One Earth Solar Farm

**Final Statement of Common Ground with Newark and
Sherwood District Council**

EN010159/APP/8.6.5

December 2025

Drawing Number:  
EN010159/APP/6.20/10.1

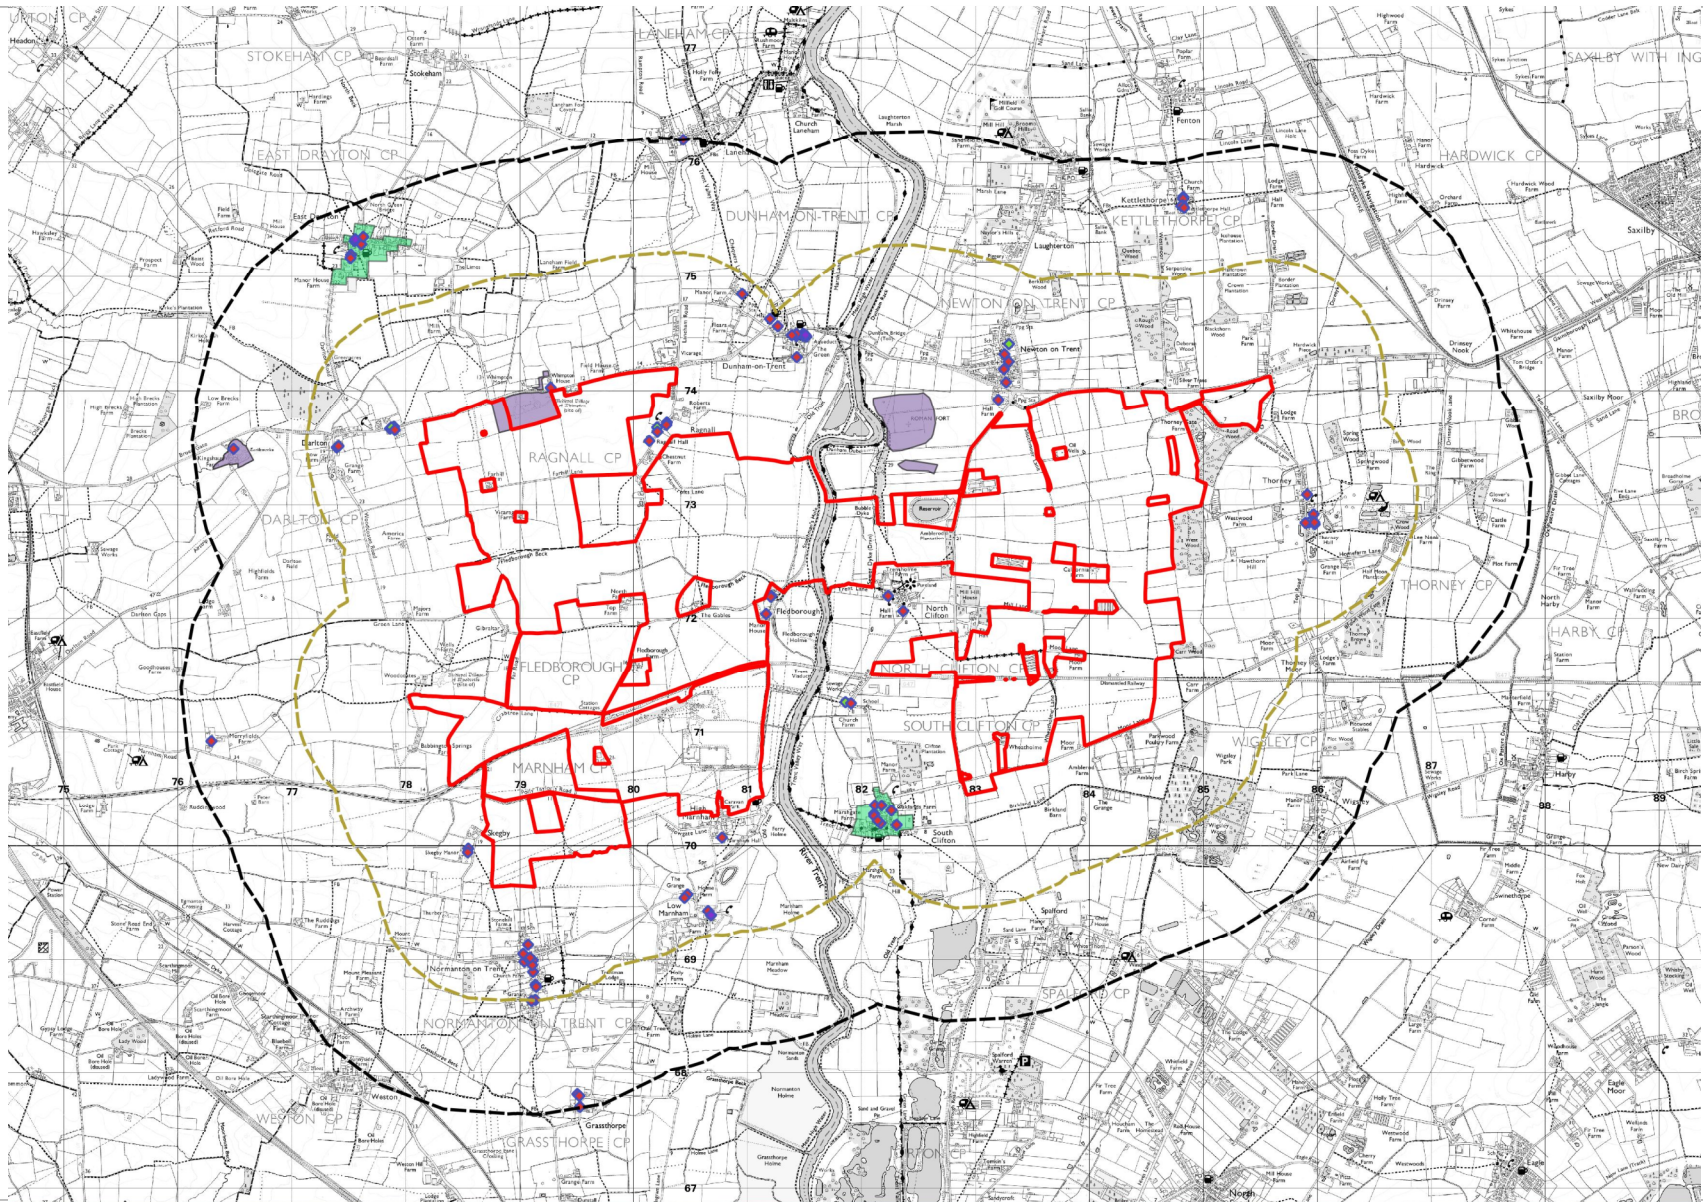
Further detail can be found in the Applicant's Response to Relevant Representations [REP1-075]	
02-08	Firs Farmhouse (Grade II)	Small strip of the solar farm seems encroach towards the heritage asset	Figure 10.1 [APP-055] of ES Chapter 10 [APP-039] confirms that the Order Limits stand at c.930m to the west of this asset. There is no stretch of the Order Limits which stand within the vicinity of the asset and no harm will arise. Further detail can be found in the Applicant's Response to Relevant Representations [REP1-075]	Agreed
02-09	Hall Farmhouse (North Clifton. Grade II, NHLE: 1302529)	There may be possible views from this heritage asset.	As illustrated within Viewpoint 25a (Figure 11.13.7 ^a [APP-068]) and assessed at paragraph 10.6.96 of ES Chapter 10 (ref. APP-039), the Order Limits would stand distant from the asset and hold no intervisibility.	Agreed
02-10	Trent Lane Farmhouse (North Clifton. Grade II, NHLE: 1369937)	There will be views in nearby field. Recommended mitigation suggest increased hedging to the south of the heritage asset.	The Order Limits would stand at distance from the asset (over 280m to the north), would not backdrop views of this asset from the Viaduct, and would hold no adverse effect on the appreciation of the asset as an agriculture farmhouse.	Agreed

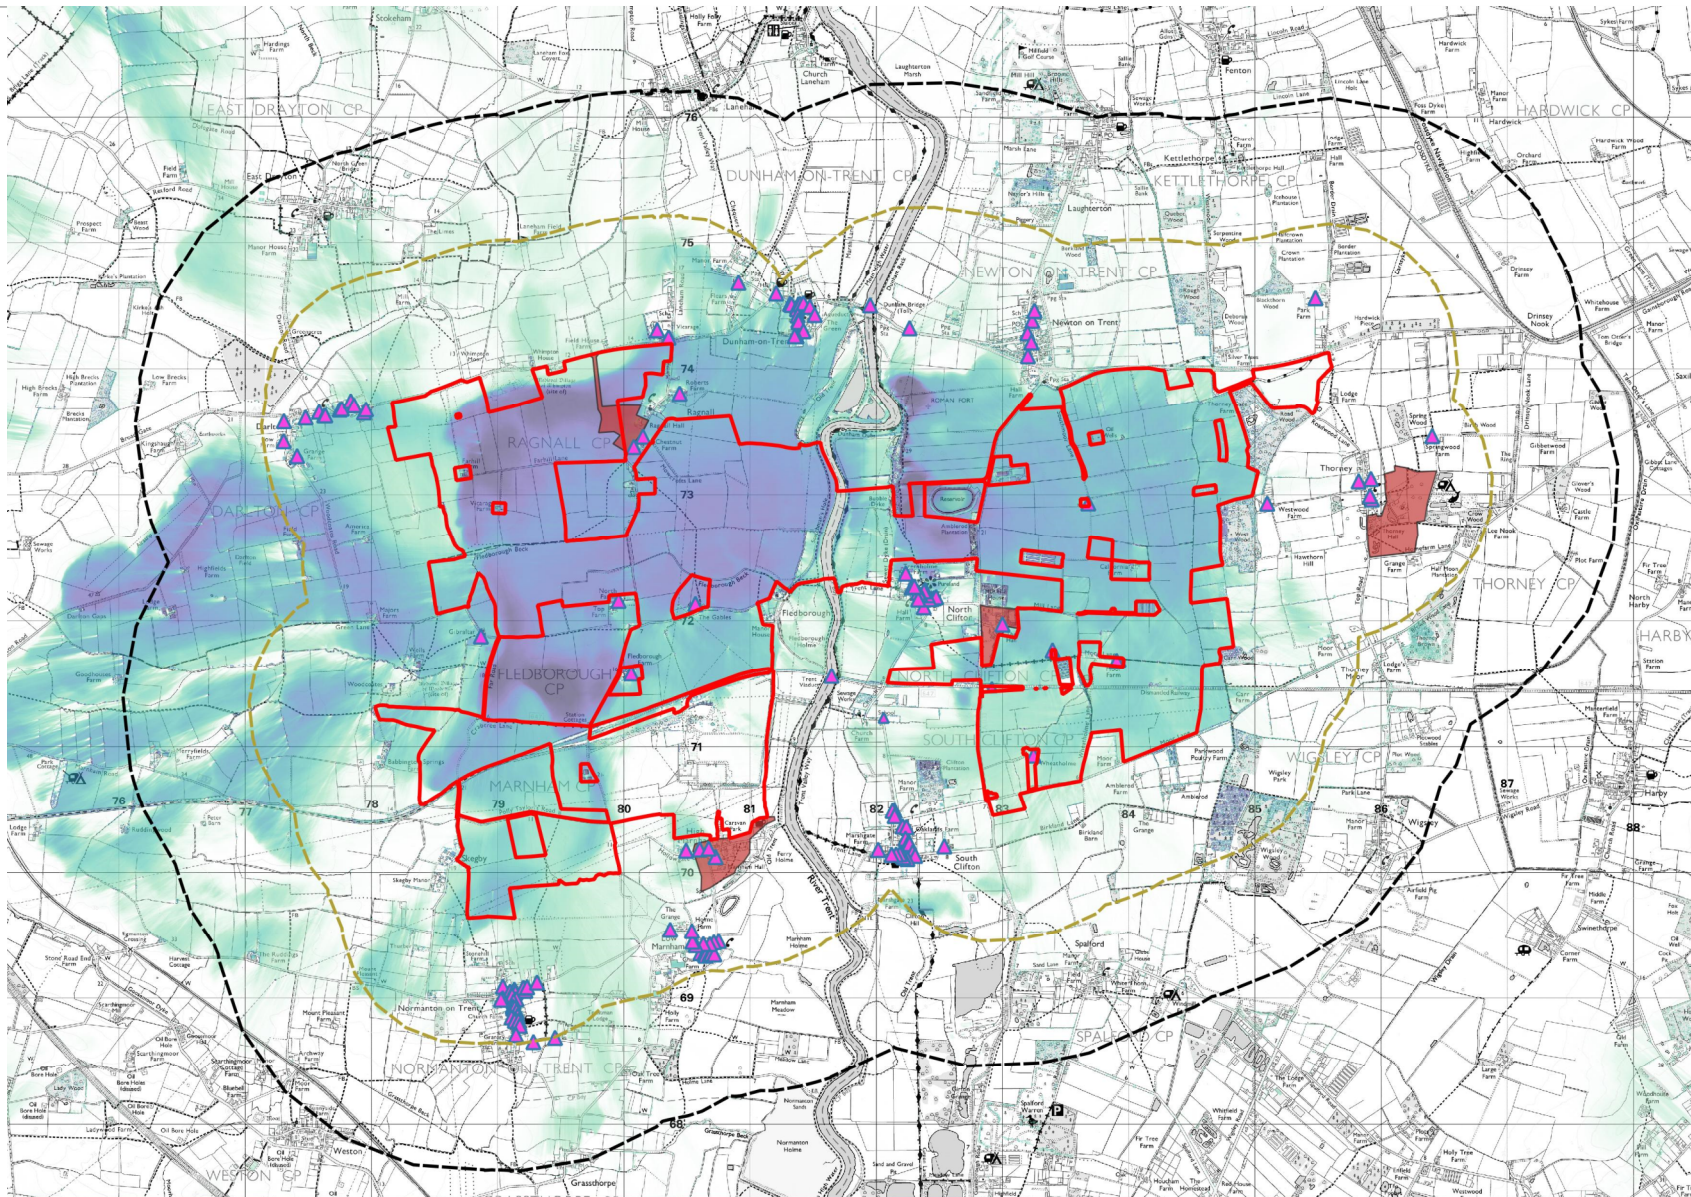
10.6.126, in paragraph 4.191 of the Technical Appendix [APP-128]. The Zone of Theoretical Visibility mapping [Figure 10.3 (APP-055)], the Proposed Development would hold no visibility. Further detail can be found in the Applicant's Response to Relevant Representations [REP1-075]	
02-05	Ruins of Old Church in Churchyard	Recommendation of further mitigation to protect any views.	This asset has been assessed in ES Chapter 10 (ref. APP-039) at paragraphs 10.6.7 and 10.6.126 and on page 85 of Appendix 10.2 (grouped with other assets in Thorney, as agreed with stakeholders – see Table 10.5 [APP-128]). The Zone of Theoretical Visibility, there would be no impact to the value (significance) of this asset, further mitigation is not required as no harm can feasibly exist which requires screening. Further detail can be found in the Applicant's Response to Relevant Representations [REP1-075]	Agreed

02-06	Lychgate at Church of St George	“Impact of proposal This listing would not be as impacted as the Church of St George due to its location, but it still forms part of the wider setting.... Recommended Mitigation None would be required for this heritage asset.”	The Zone of Theoretical visibility (Figure 10.3 [APP-055]) confirms no intervisibility of the Proposed Development. There would be no effect on the appreciation of the church, churchyard and lychgate Therefore, this asset would not change the assessed effects (or lack thereof) on the Church of St George the Martyr (Grade II*). Further detail can be found in the Applicant’s Response to Relevant Representations [REP1-075]	Agreed
02-07	Fledborough Viaduct	The impact of solar panels either side would be detrimental to the wider setting of the viaduct.	No solar arrays are to be located on either side of the viaduct as the land is not included within the Order Limits. It is unclear which northern small parcel is recommended for removal; to clarify the nearest Order Limit north of the Site is at c.660m. As noted within paragraphs 10.6.68 – 10.6.71 of ES Chapter 10 [APP-039], the industrial historic interest of the asset is not reliant on views of a particular character of the landscape to understand its value. The Proposed Development would hold a negligible neutral effect and result in no change to the contribution of the wider setting to asset’s value.	Agreed
